Application for a non-material amendment following a grant of planning permission.

DEMOLITION OF ATTACHED PREFABRICATED GARAGE & UTILITY AREA.  
REPLACEMENT WITH SINGLE STOREY EXTENSION TO PROVIDE ELDERLY  
RELATIVE ANNEX TO THE WEST ELEVATION, AND A GLAZED  
CONSERVATORY TO THE EAST ELEVATION

FG / 123 / 08

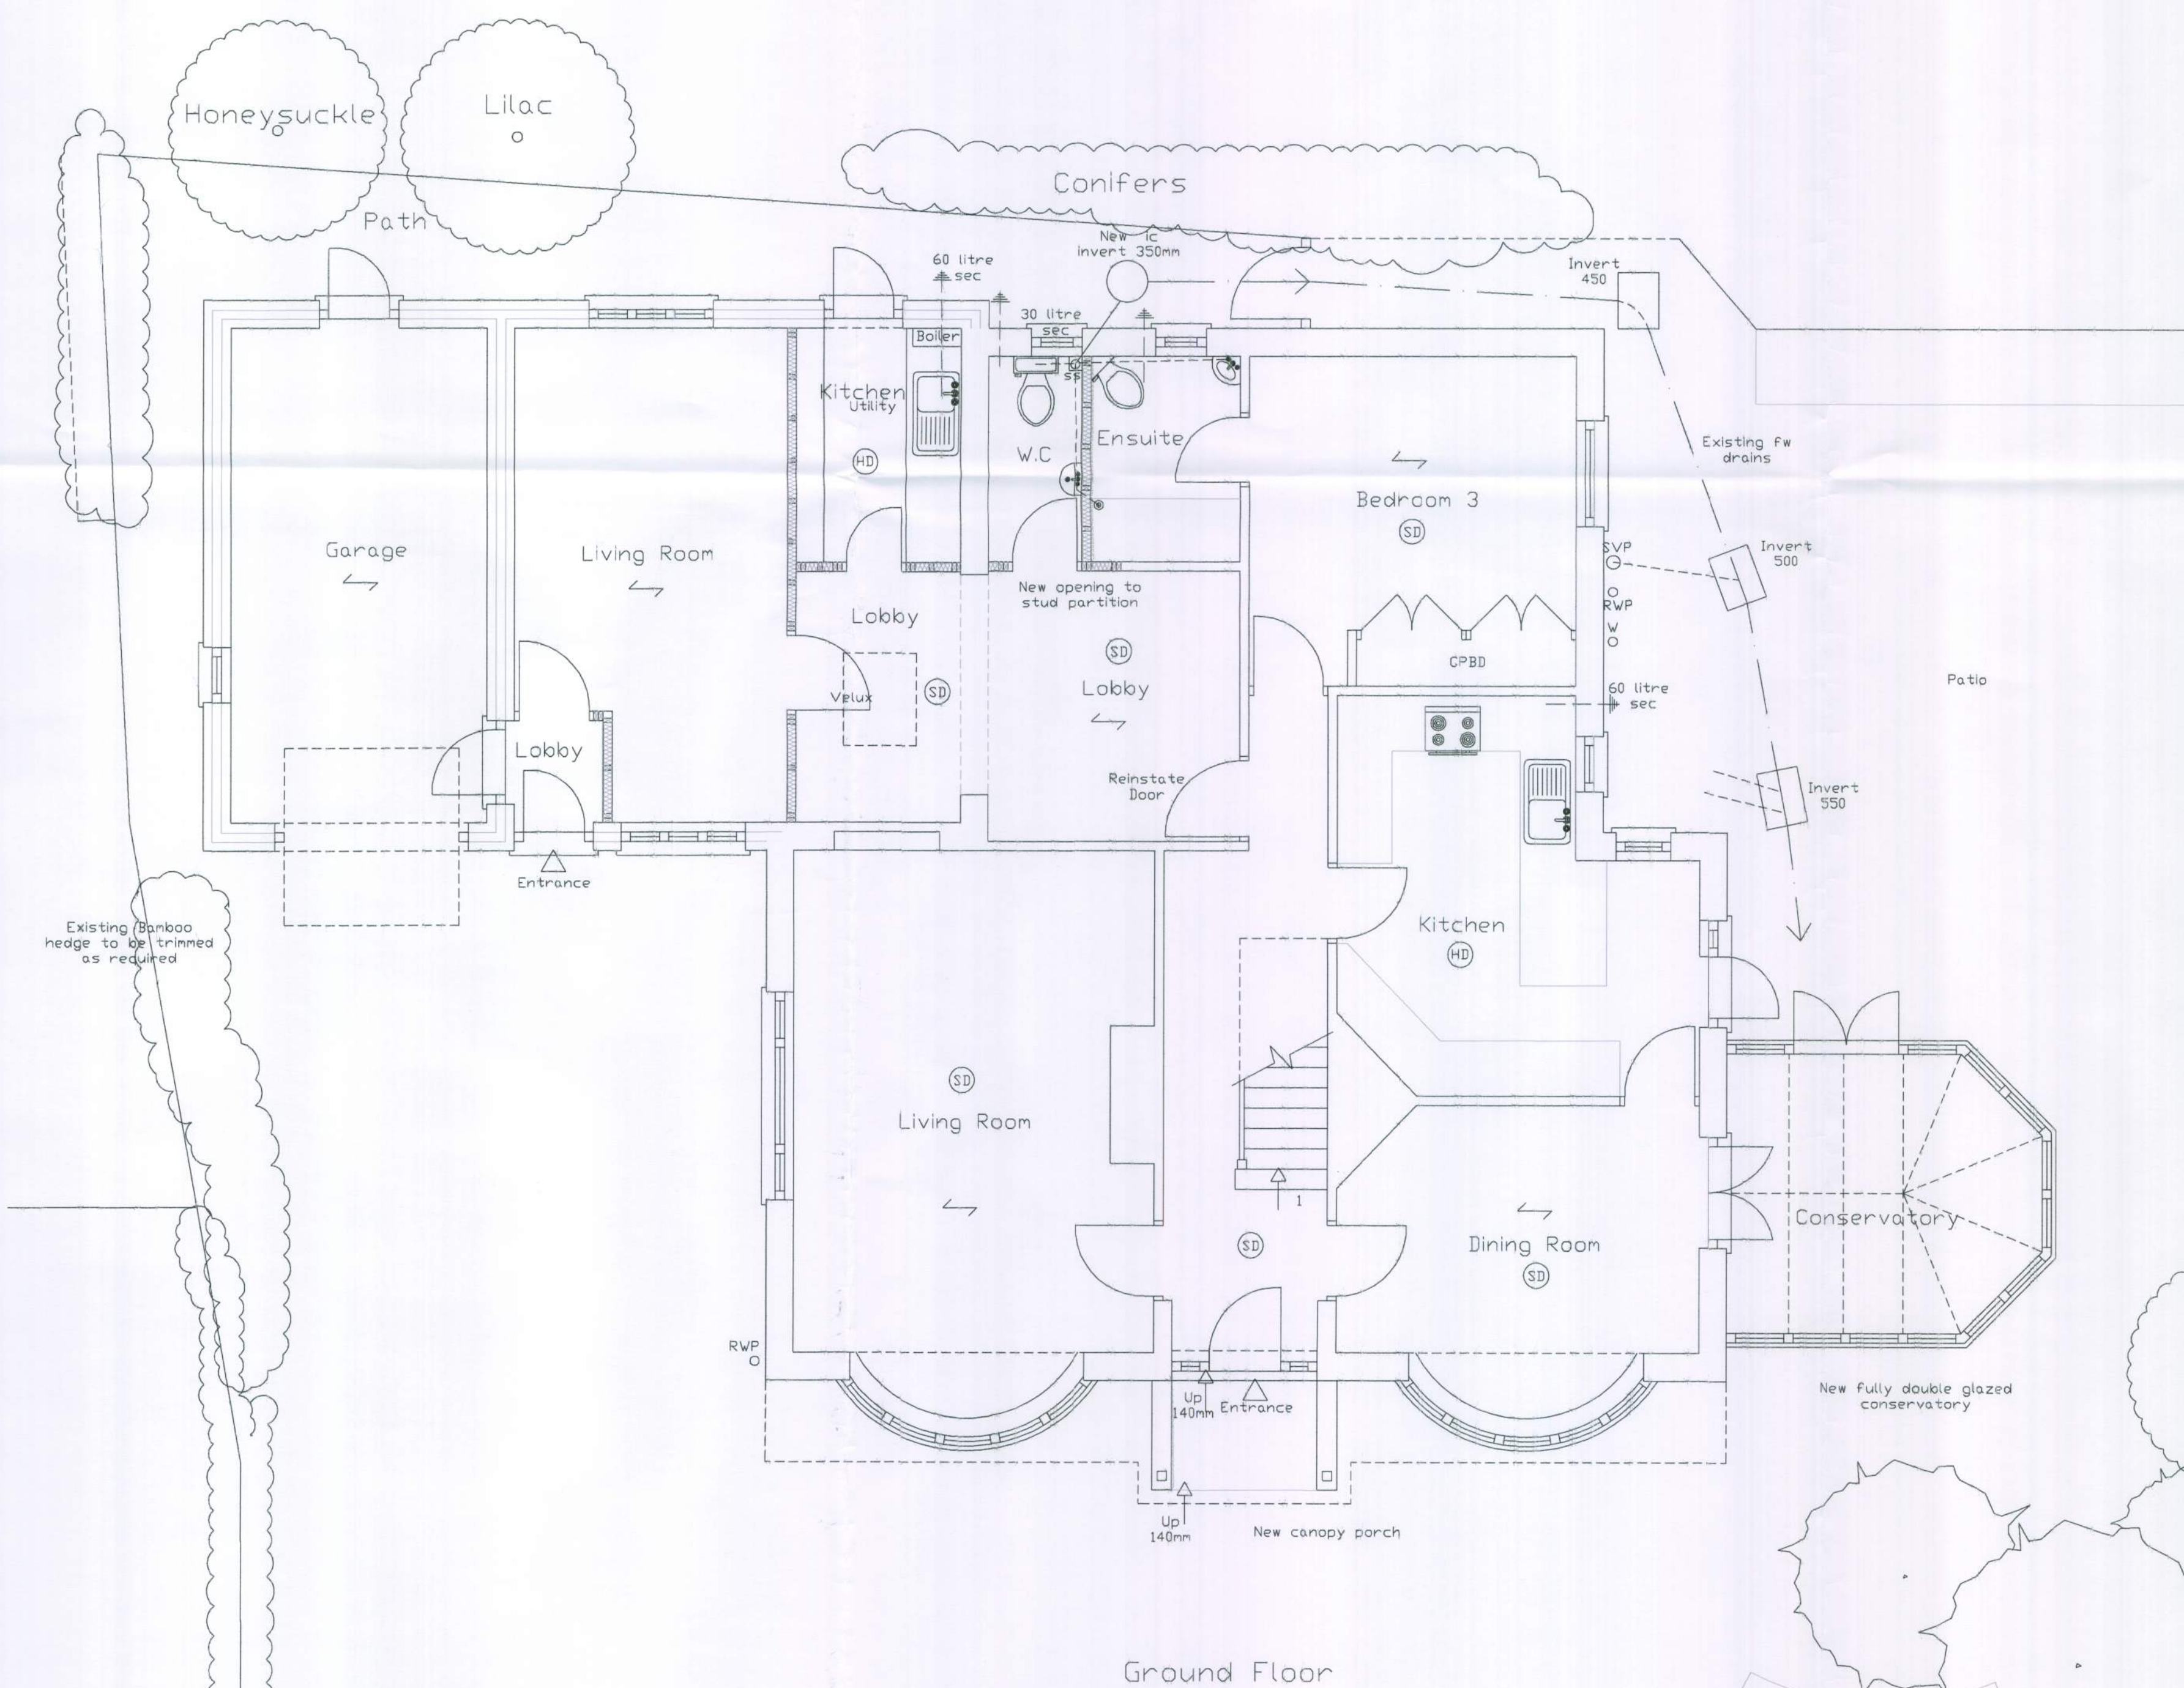
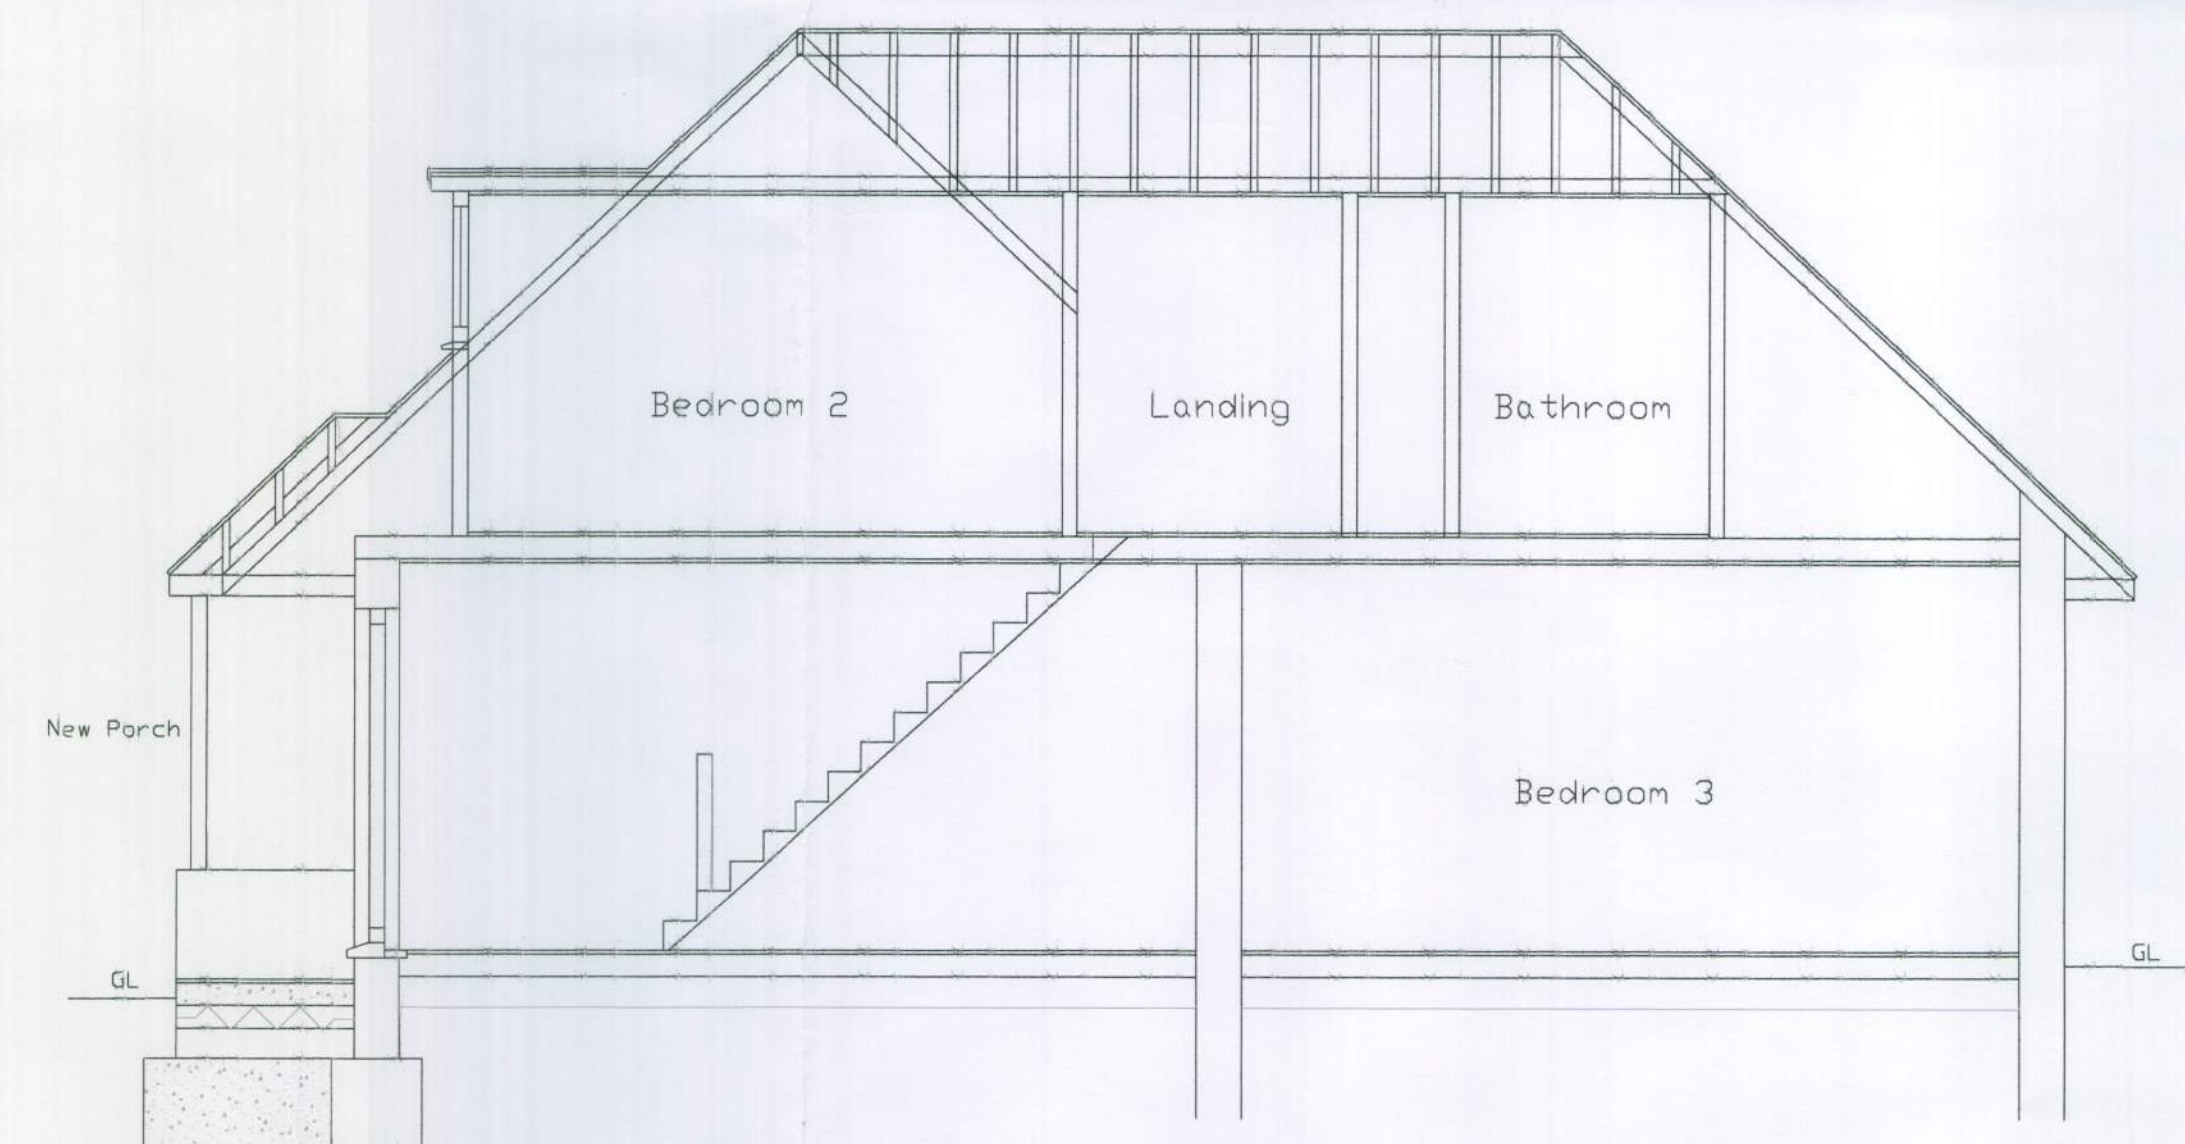
- REDUCTION IN SIZE OF THE APPROVED DRAWINGS TO EXCLUDE THE FRONT GARAGE & STORE AREA, BUT TO INCLUDE ALTERATIONS TO THE INTERNAL LAYOUT WITH SUBSEQUENT AMENDMENTS TO WINDOWS & DOORS.
- REDUCTION IN SIZE OF CONSERVATORY FROM 12.5 SQM TO 10 SQM, WITH REDUCTION IN HEIGHT AND AMENDMENT TO DESIGN.

191.10.01 191.10.02 191.10.03 191.10.04
